VPI Immingham OCGT Project

Document Ref: 7.8
PINS Ref: EN010097

The Applicant's Comments on Responses to the Written Questions

Examination Deadline 3

Drawing Title
**SURFACE WATER FEATURES
 WITHIN THE STUDY AREA
 FIGURE 12.1**

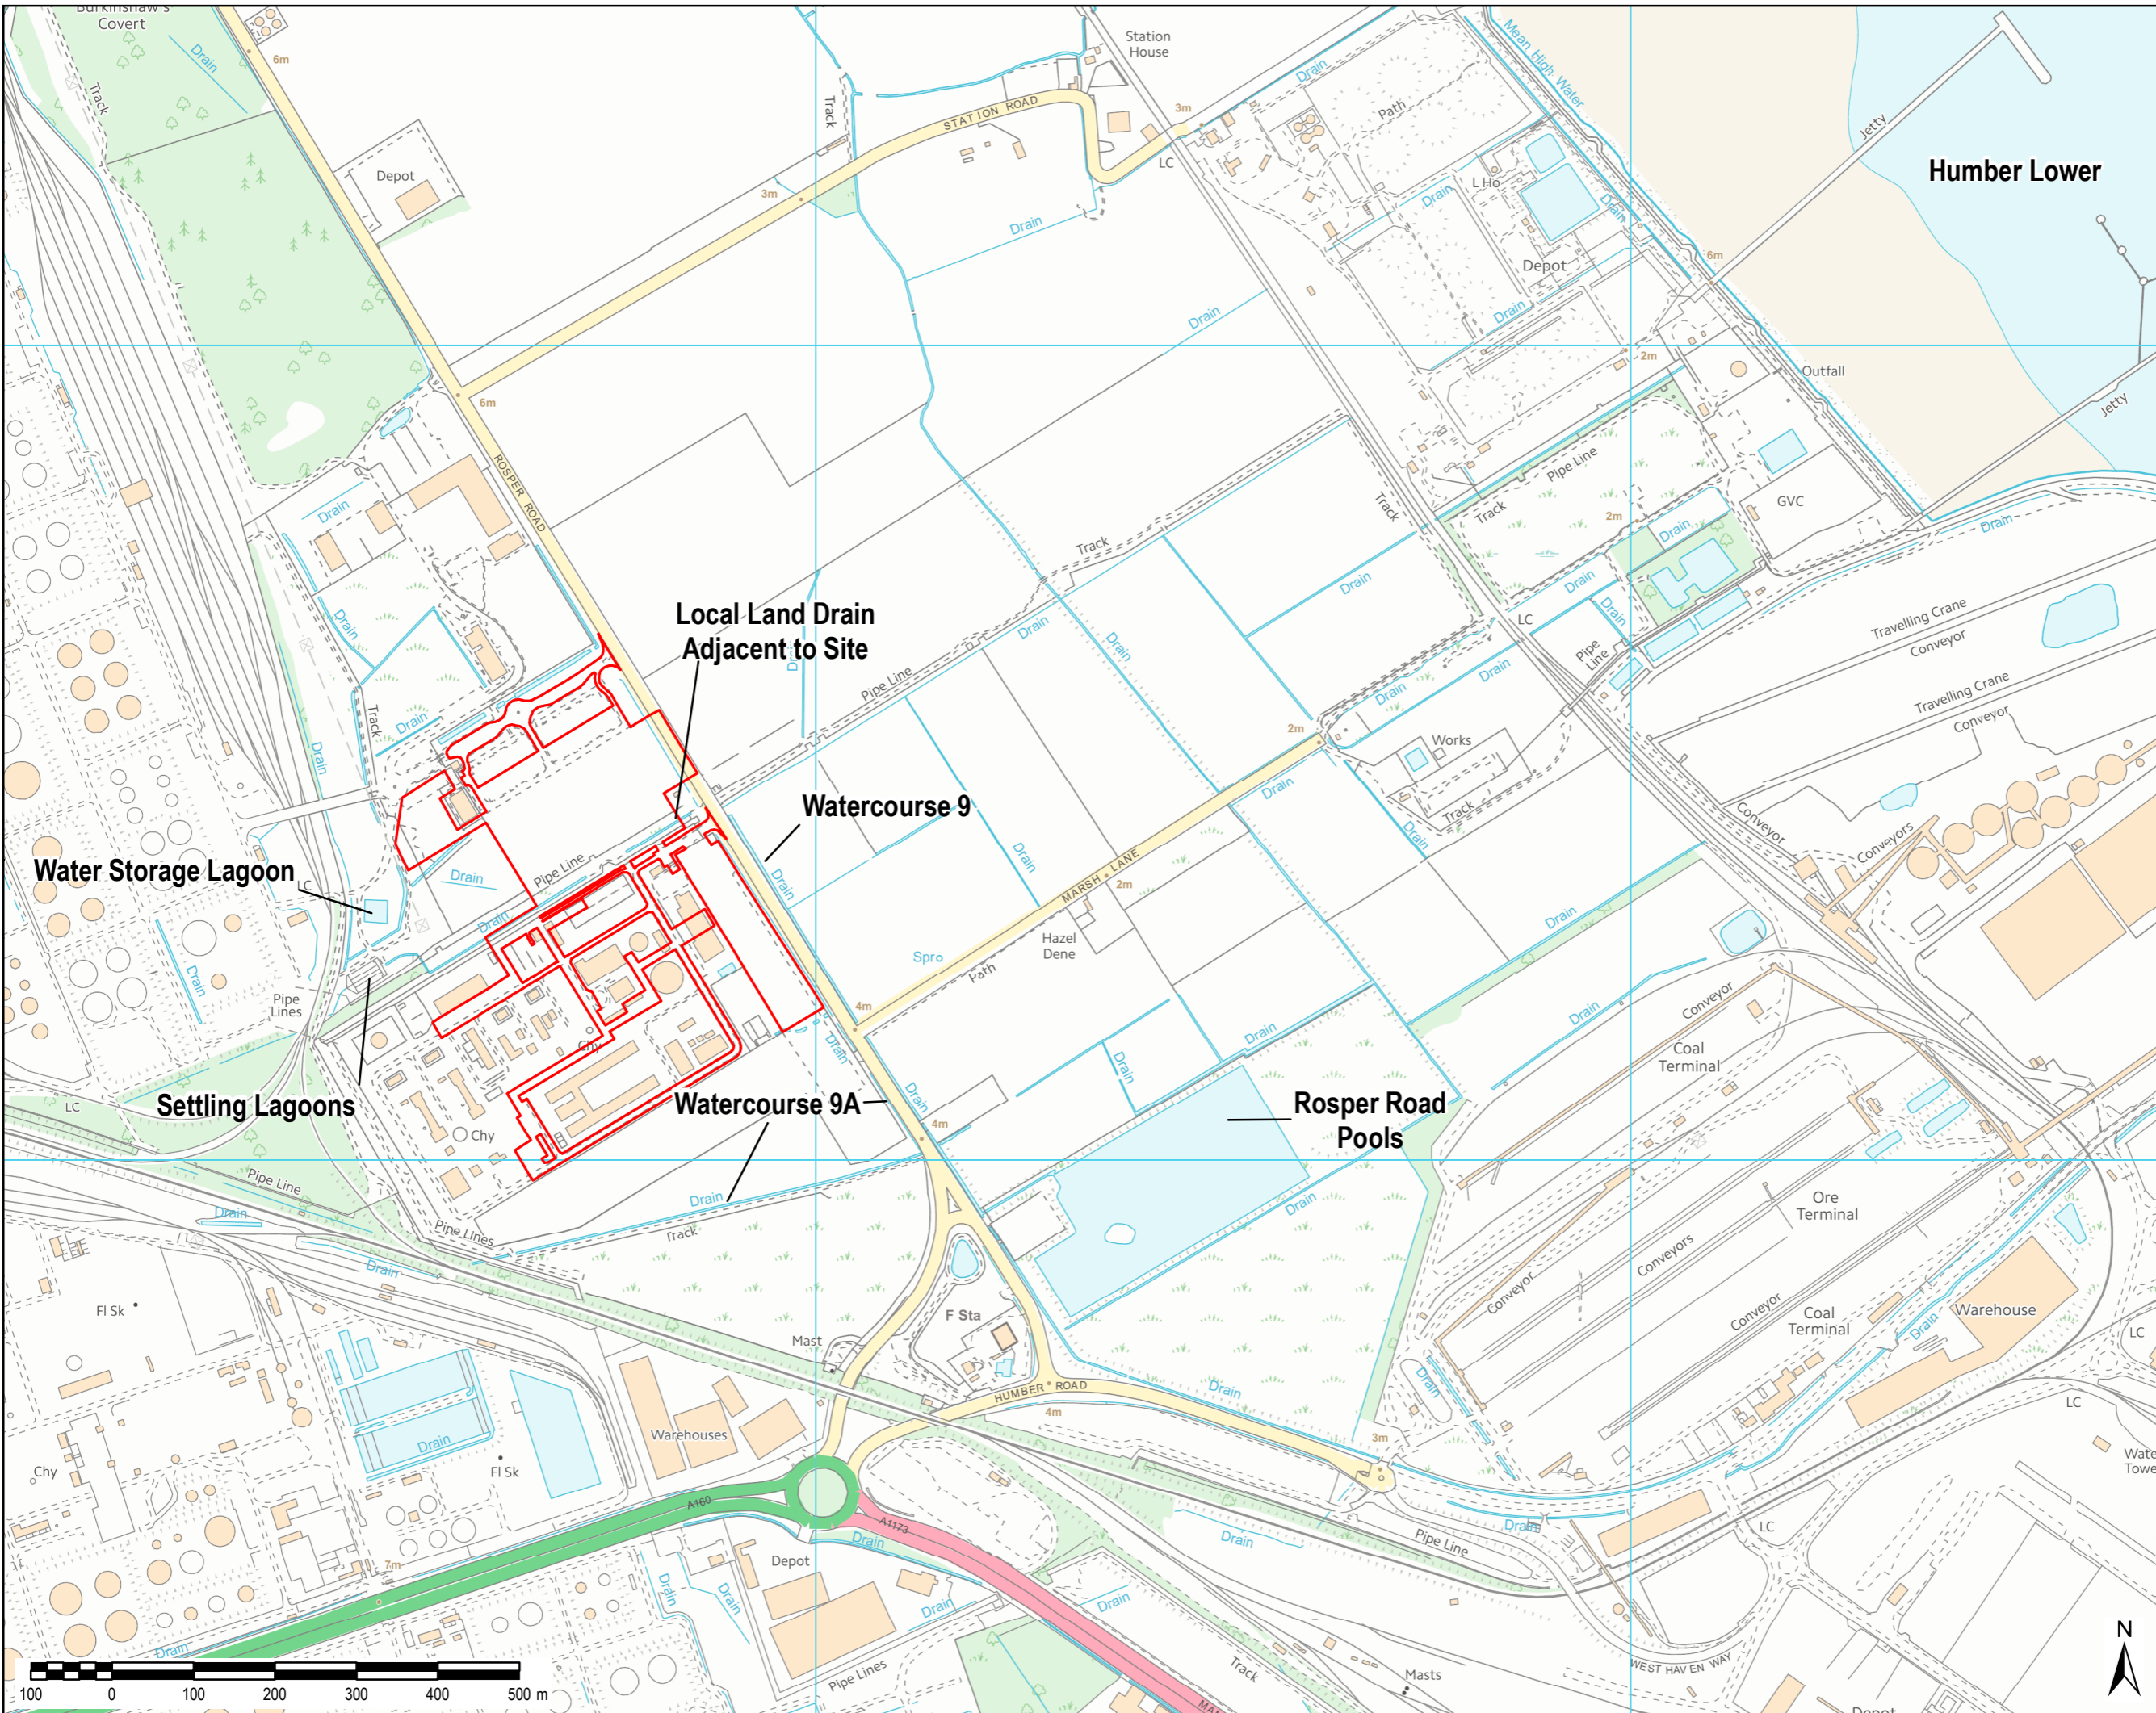
<p>Q1.6.1 WFD Assessment Table 12.4 of ES Chapter 12 [APP-041], in response to comments from the SoS, states that as there are no works directly affecting the local watercourses,</p>	<p>The EA is satisfied that the assessment of the impacts on local watercourses has been adequately undertaken (we would point out that there is an error in paragraph 12.2.27 of Chapter 12, which should reference the Louth, Grimsby</p>	<p>The Applicant welcomes the EA's confirmation of their satisfaction with the impact assessments and the associated DCO requirements. The Applicant can confirm that error identified is a typographic</p>

Written Question	Environment Agency's Answer	Applicant's Response
<p>including the River Humber, a standalone WFD assessment has not been completed.</p> <p>Please provide confirmation that there are no direct or indirect pathways through which the terrestrial works would directly or indirectly affect the surrounding watercourses. Please comment on the adequacy of the above approach.</p>	<p>and Ancholme Catchment – not the Tame, Anker and Mease Catchment).</p> <p>Subject to the implementation of appropriate pollution prevention measures during construction and operation of the proposed development, there is no reason to believe that there would be any direct or indirect impact on surrounding watercourses. We are satisfied that there are various requirements in the DCO (for example the CEMP, contaminated land and groundwater etc), which secure appropriate mitigation and provide for further consultation to be undertaken on the detailed measures, prior to development commencing. There will also be appropriate conditions in the Environmental Permit, to safeguard the water environment during operation of the plant.</p>	<p>one and not one that affects the assessment in any way.</p>

Drawing Title
OTHER DEVELOPMENTS CONSIDERED FOR CUMULATIVE IMPACTS FIGURE 17.1

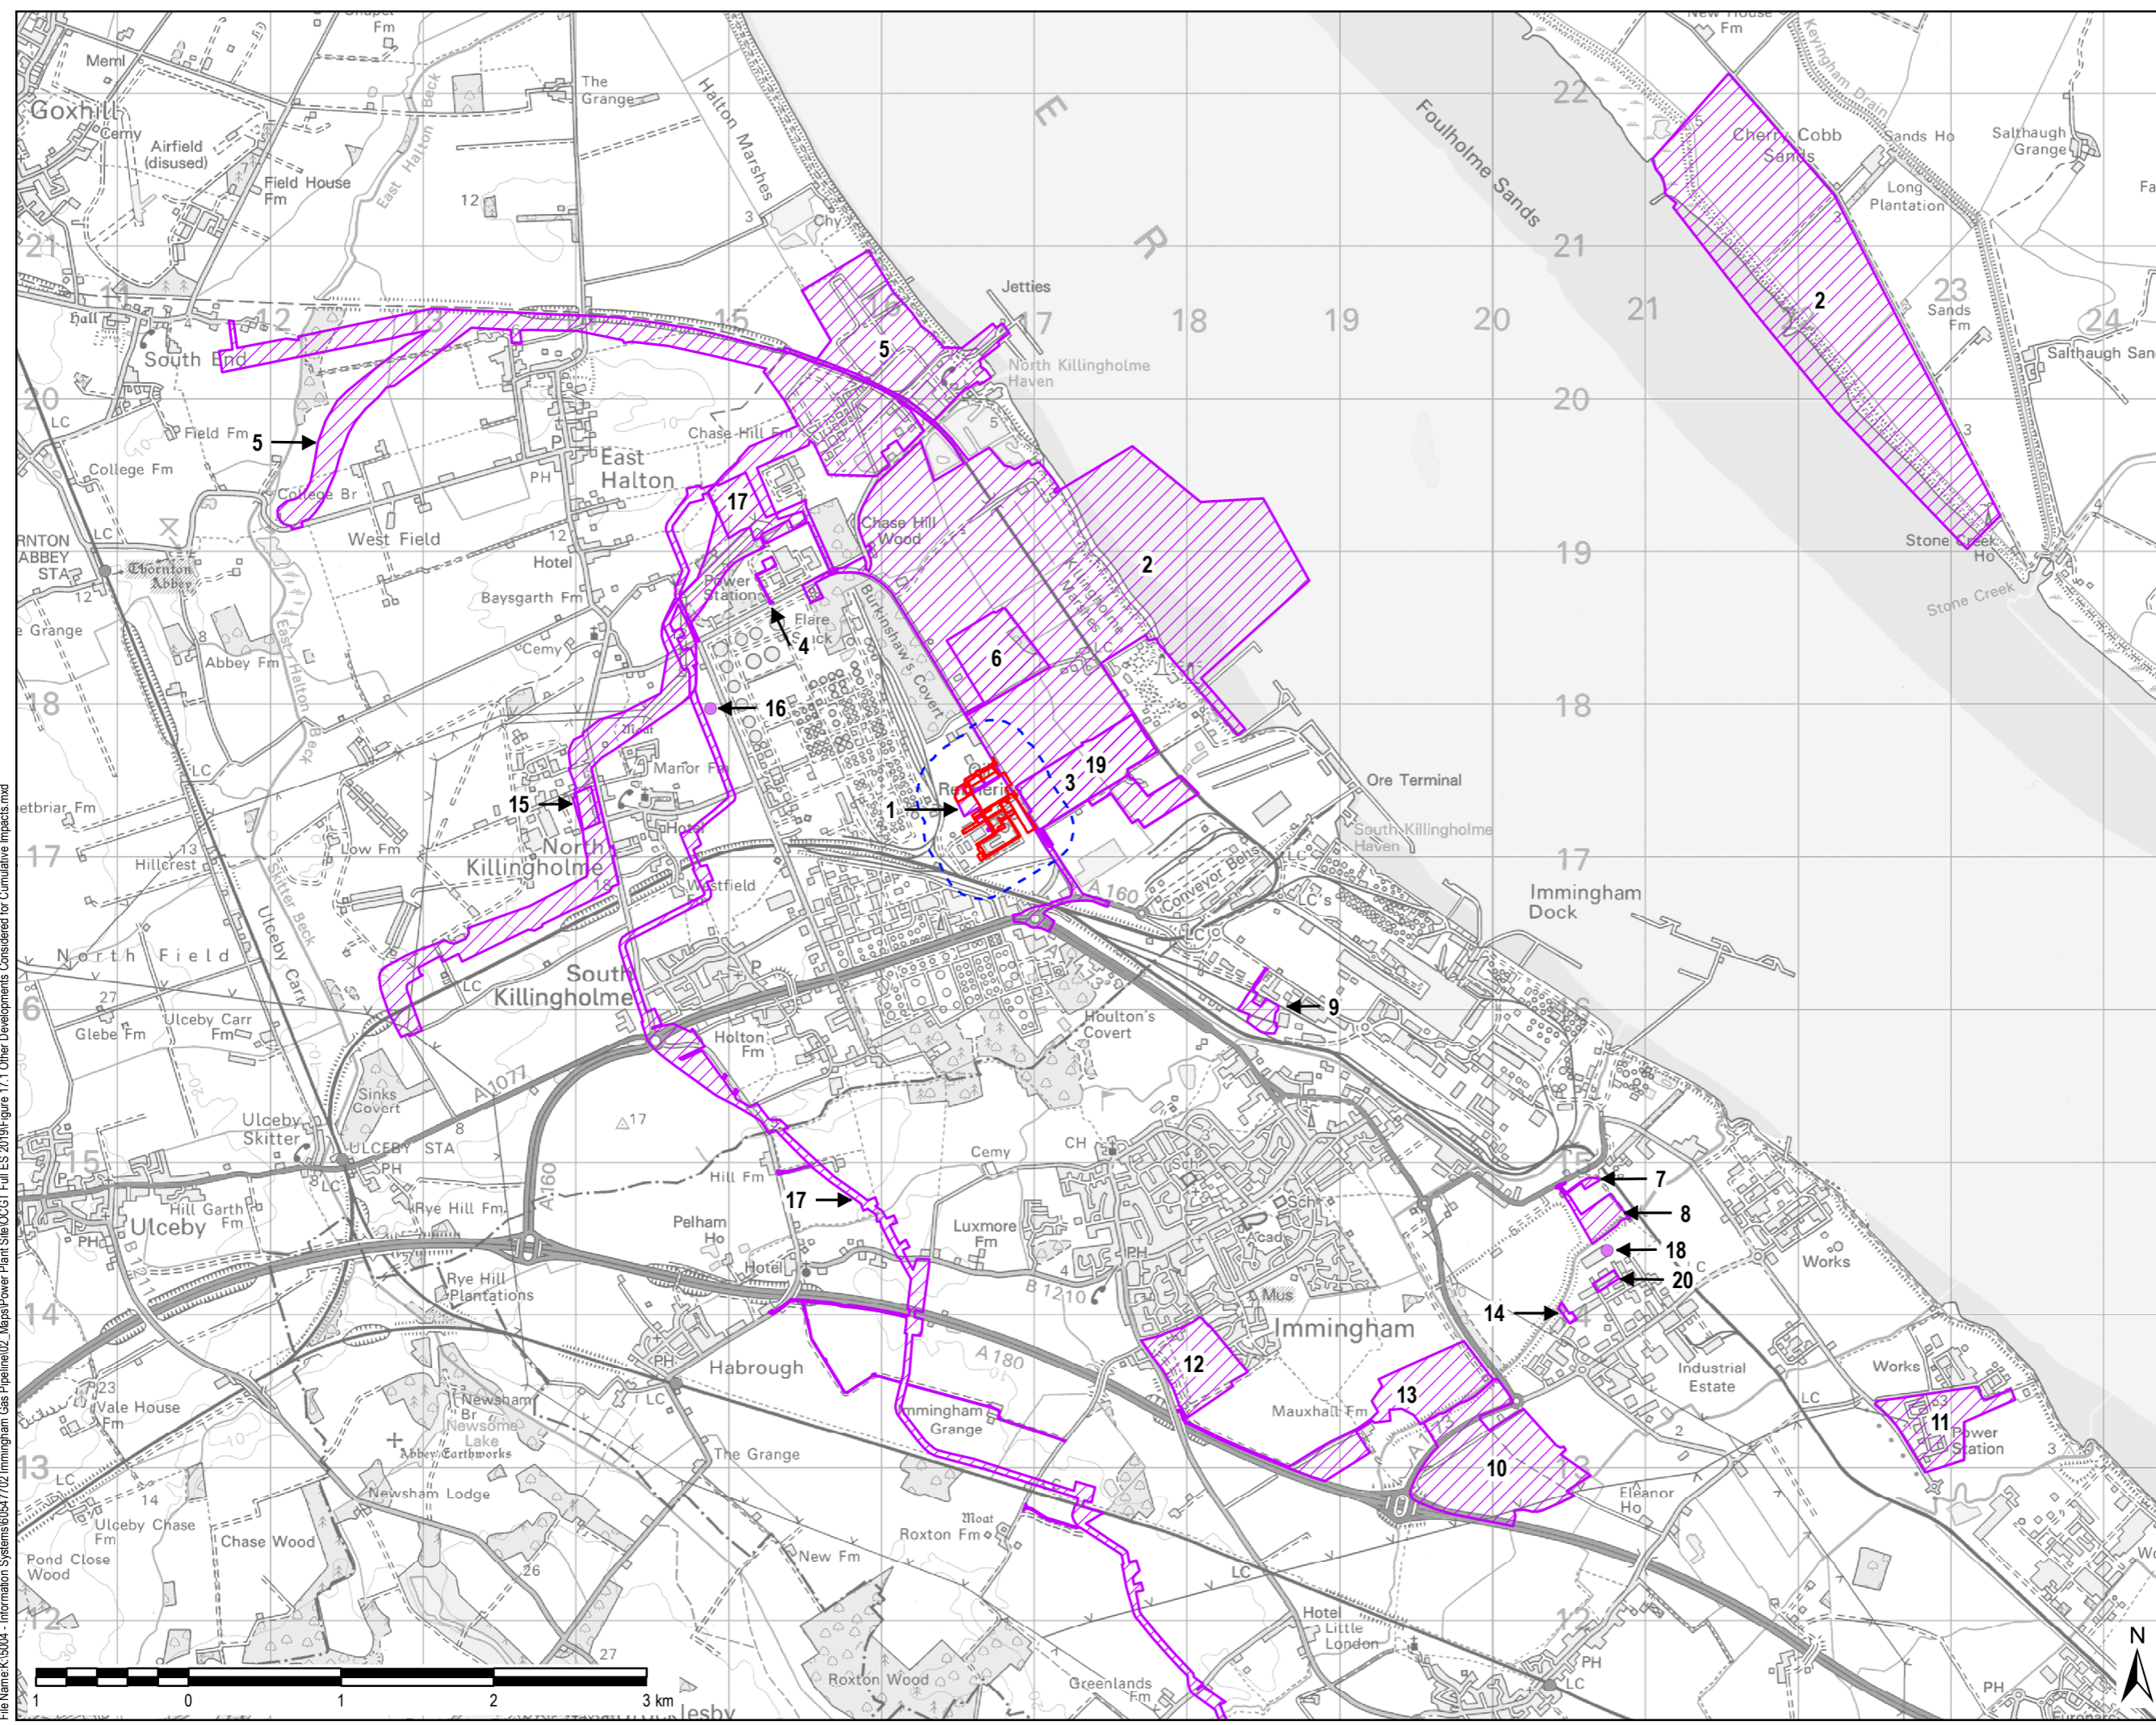
Written Question	North Lincolnshire's Answer	Applicant's Response
<p>Question 1.5.1 – Cumulative effects</p> <p><i>Table 17.3 of Chapter 17 of the ES [APP-046] provides a list of other developments identified in stage 2 of the cumulative effects assessment.</i></p> <p><i>Please confirm whether you are aware of any other projects or plans that should be included in the cumulative effects assessment.</i></p> <p><i>Please confirm that NLC and NELC are satisfied that the list of projects set out in Table 17.3 of Chapter 17 of the ES [APP-046] includes all of the developments that need to be taken into account in the assessment of cumulative effects.</i></p>	<p>NLC is satisfied that the list of projects set out in Table 17.3 of Chapter 17 of the ES [APP-046] includes all of the developments that need to be taken into account in the assessment of cumulative effects.</p>	<p>The Applicant notes that NLC are satisfied with the list of projects in Table 17.3 of Chapter 17 of the ES.</p>
